Our reference: EF13/3893, DOC16/52234-02
Contact: John Goodwin

SSD 7311 – TARONGA ZOO RESEARCH AND EDUCATION FACILITY EIS

ATTACHMENT A

TARONGA ZOO RESEARCH AND EDUCATION FACILITIES

Taronga Zoo: Thursday 29 October, 2015

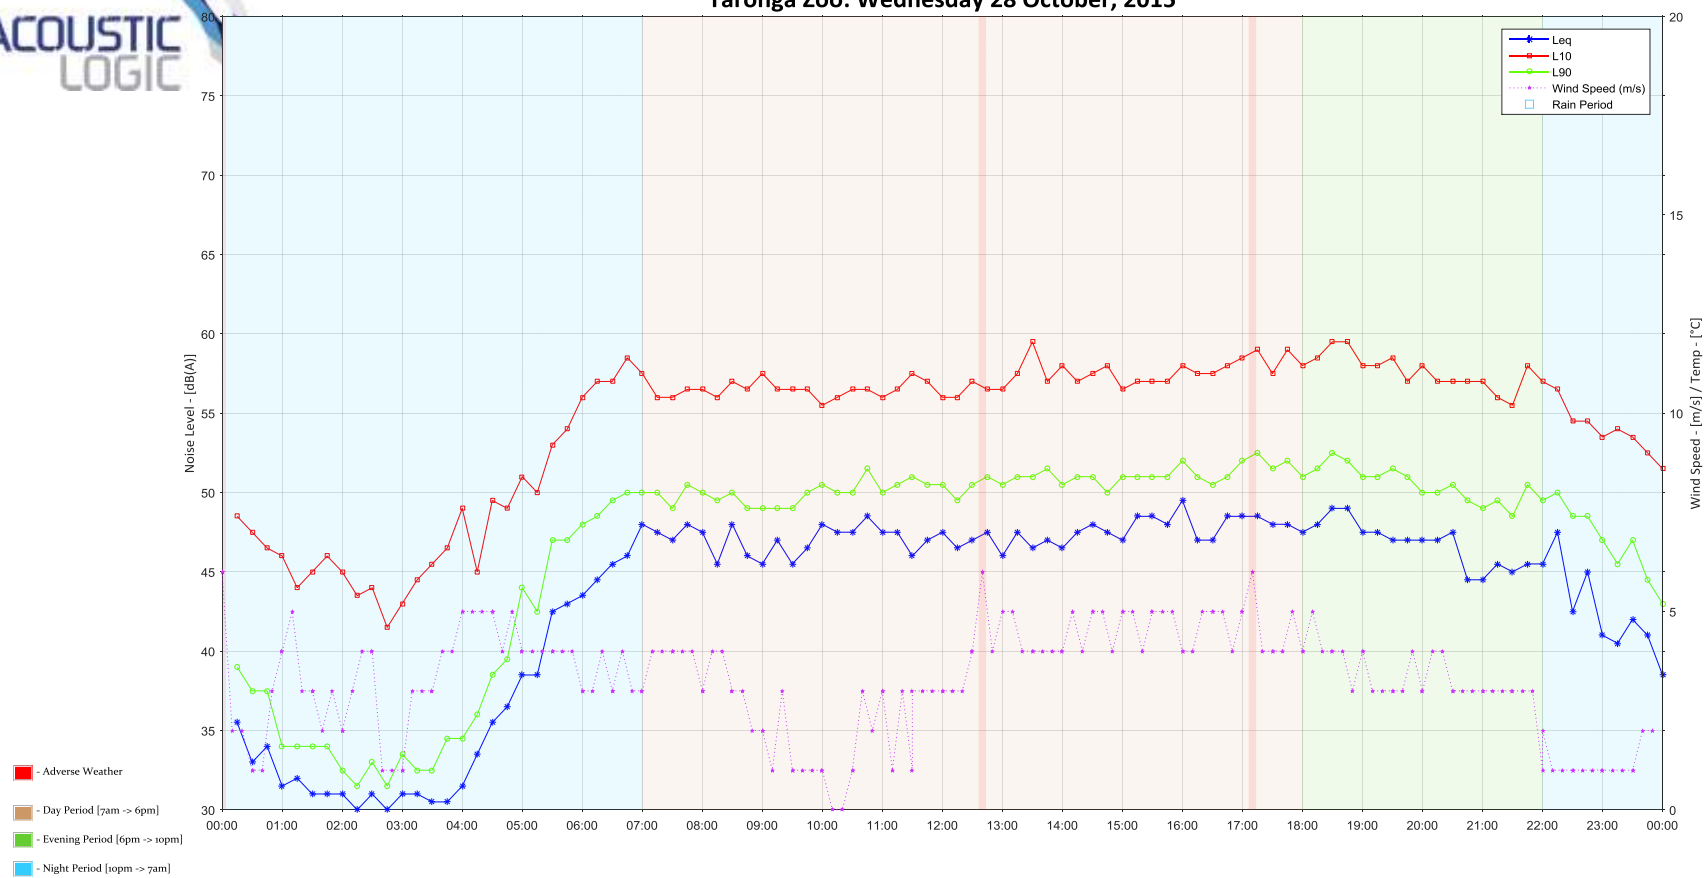
However, the EPA notes that the noise monitoring graphs attached to Appendix N are labelled 23 October 2015 to 29 October 2015. Nevertheless, on the assumption that the noise monitoring was actually undertaken in October 2015 rather than September, rain and wind speeds exceeding 18 kilometres per hour were also observed on several days between 23 and 29 October 2015.

EIS Appendix N does not appear to provide any justification for not excluding the weather affected noise monitoring data used to establish the measured background noise levels presented in Table 2, which data may have been conflated by unfavourable meteorological conditions.

The proponent be required to establish background noise levels for the locality by undertaking noise monitoring in accordance with guidance material provided in Chapter 3 to the NSW Industrial Noise Policy.
